## A303 Stonehenge - Amesbury to Berwick Down – Supplementary Consultation

Please note this response is made in addition to the comments previously sent (dated 15 April 2018).

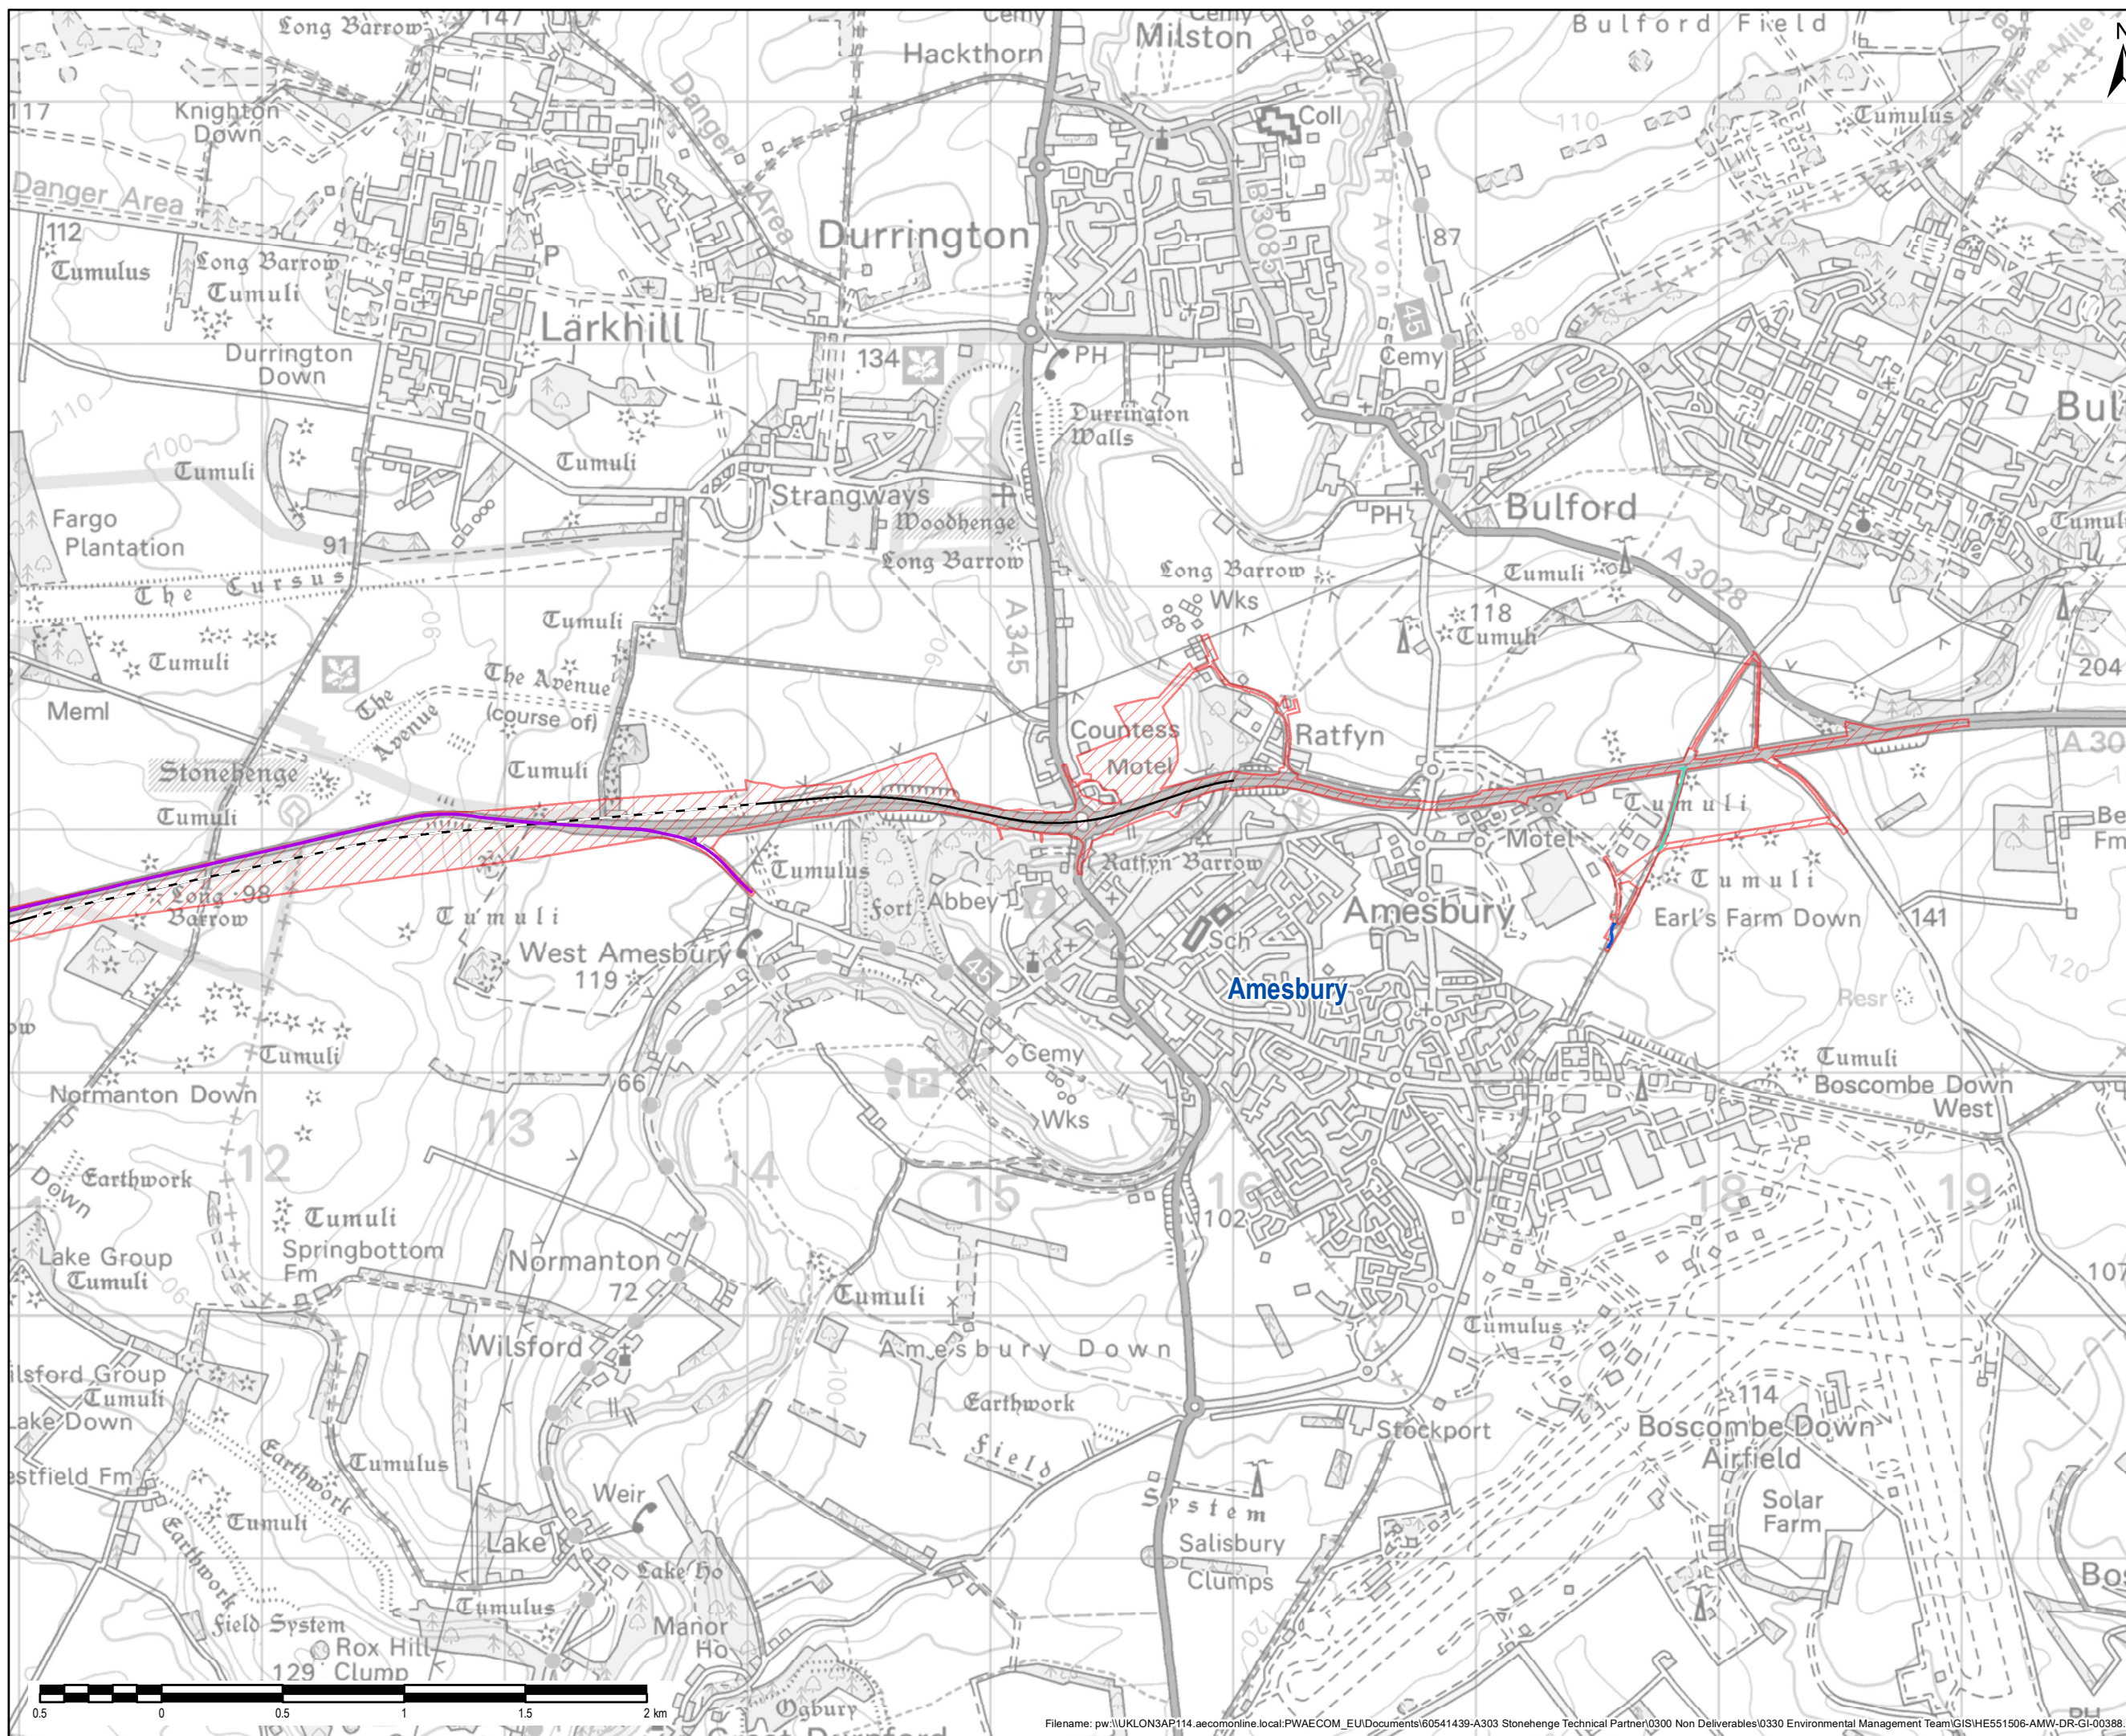
Preference for leaving Byway 11 as it is (to intersect with the new Stonehenge Byway on the alignment of the A303) and not create a new link, to Byway 12. This will avoid creating confusion for all NUMs consulting maps of the area, and as Byway 11 will become a cul-de-sac for motorised traffic, it may improve the amenity it currently provides for all NUMs by the link it provides out of the WHS south to the Woodford Valley at Lake and Wilsford.

The wider green bridge proposal is supported as this will reduce the impact of the dual A303 for all NUMs on the proposed new restricted byways, both north/south and east /west (in fact it is a pity that the tunnel can't extend to nearer the existing A360 to further reduce its impact on the western WHS).

Given that the road to Larkhill from here will be part of the emergency diversion in event of tunnel closure, on behalf of all types of cyclists (along no doubt with horse riders), we would also like to see an extension of the proposed restricted byway from Airman's Corner north to Rollestone Crossroads. Provided this has a suitable bound surface (as proposed further to the south) and a safe means to cross the 'curve', it will not only make use safer for all NUMs, but also reduce the disruption to traffic flow by providing an alternative to on-road use of this north/south link across the plain for slower moving traffic such as cyclists.
